OUT18/11894

**Borg Panels Timber Processing Facility (SSD 7016) MOD 1 –
Additional RTS information**

Alison Collaros
A/Manager, Assessment Advice
Lands and Water - Strategy and Policy
18 September 2018

Figure 3 Construction plan for reclamation works

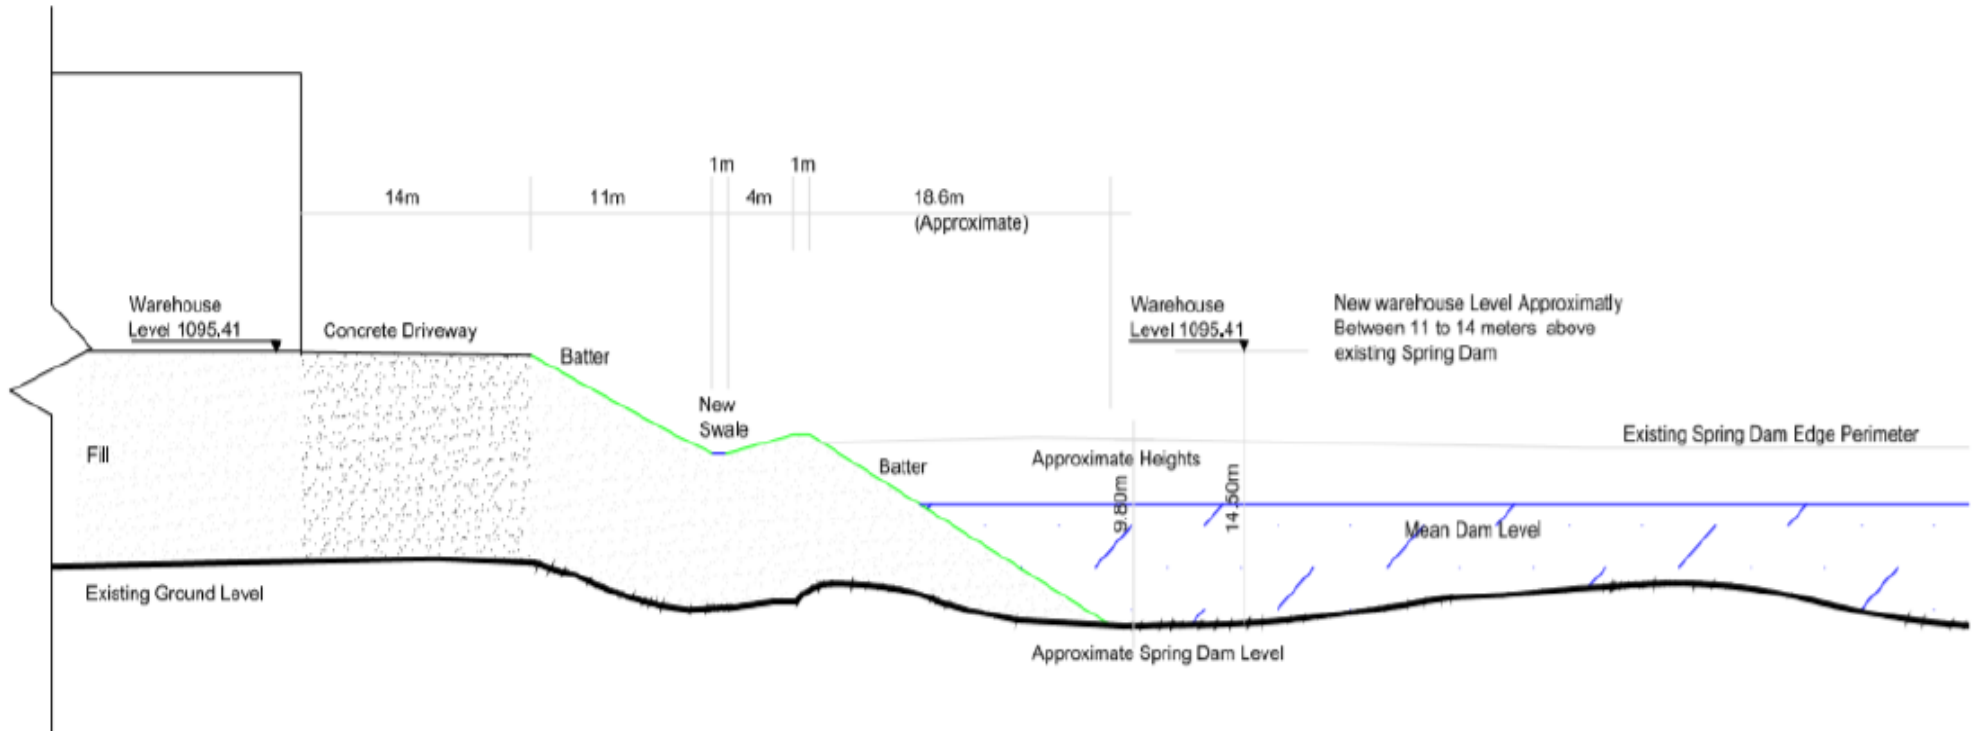
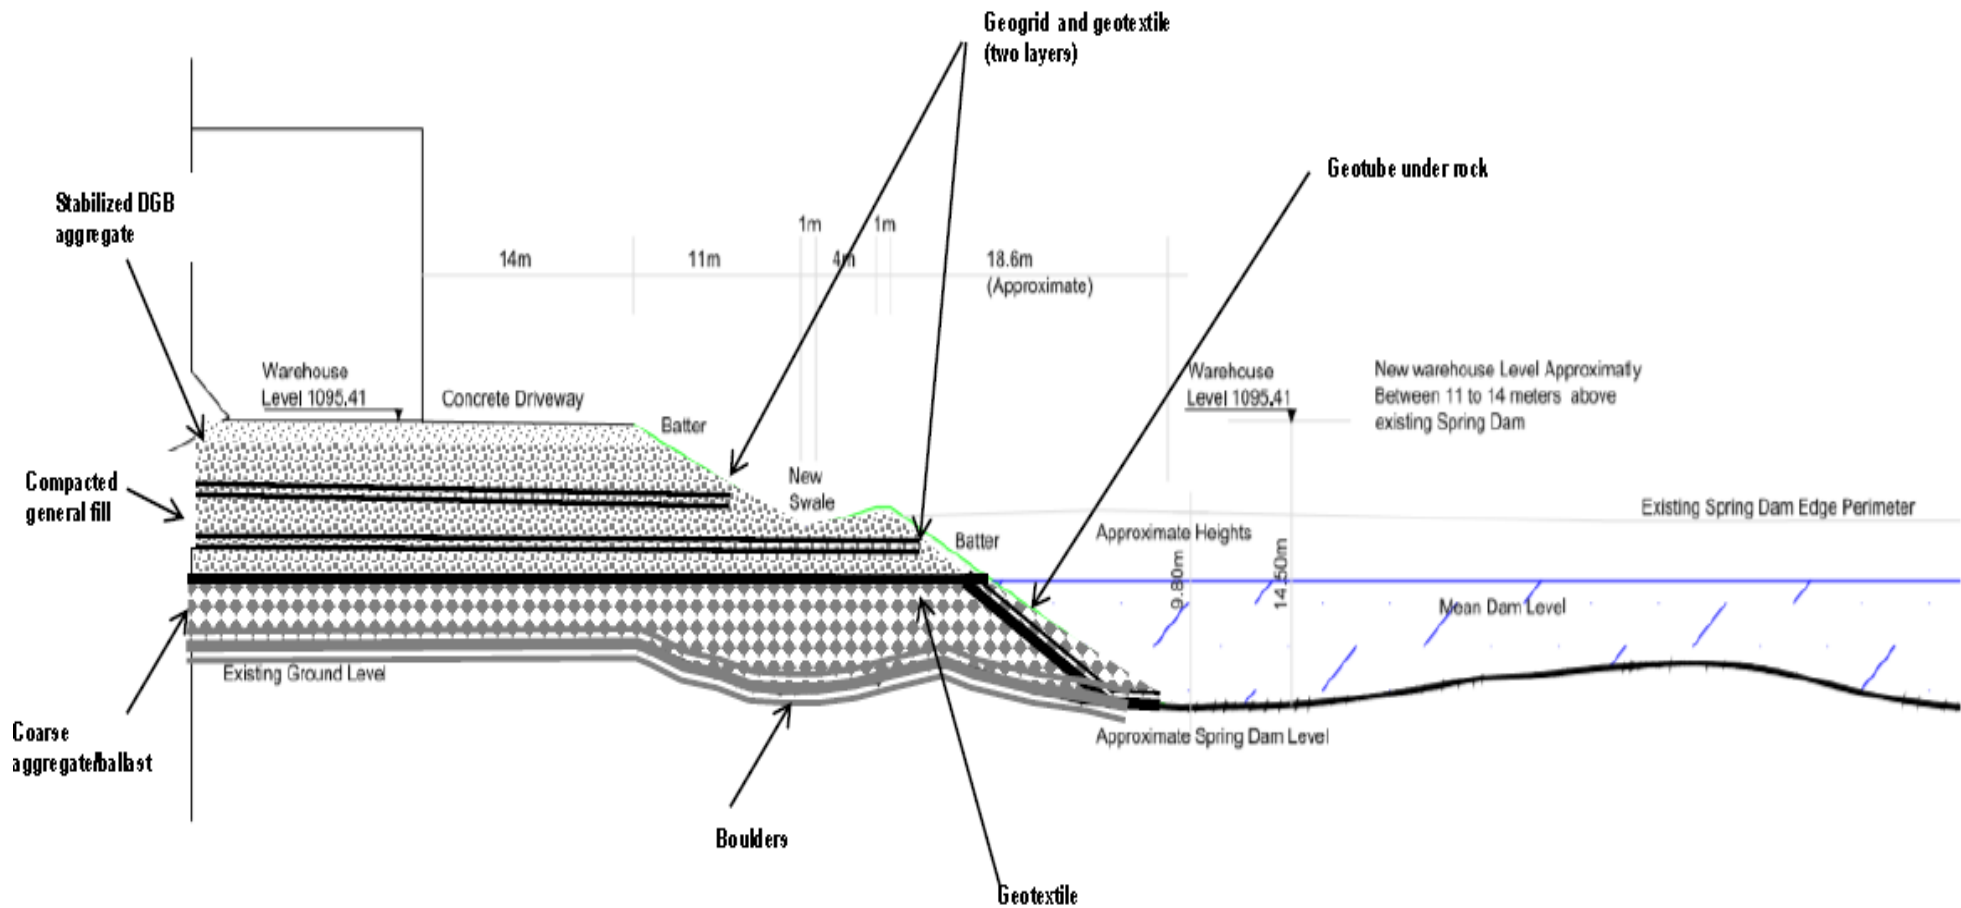
- The reclamation methodology should ensure sufficient permeability of the fill material to maintain groundwater flow paths.
- Management measures should be implemented to mitigate impacts to the water quality of Spring Fed Dam during construction and operation. This is to also mitigate potential impacts to the connected groundwater and surface water sources.
- An erosion and sediment control plan should be developed in accordance with relevant industry standards eg. *Managing Urban Stormwater: Soils and Construction* (Landcom 2004).
- The Stormwater Management Plan should be updated in consultation with Lands and Water prior to commencement of construction.
- Works within waterfront land should be in accordance with the, *Guidelines for Controlled Activities on Waterfront Land* (NRAR 2018).
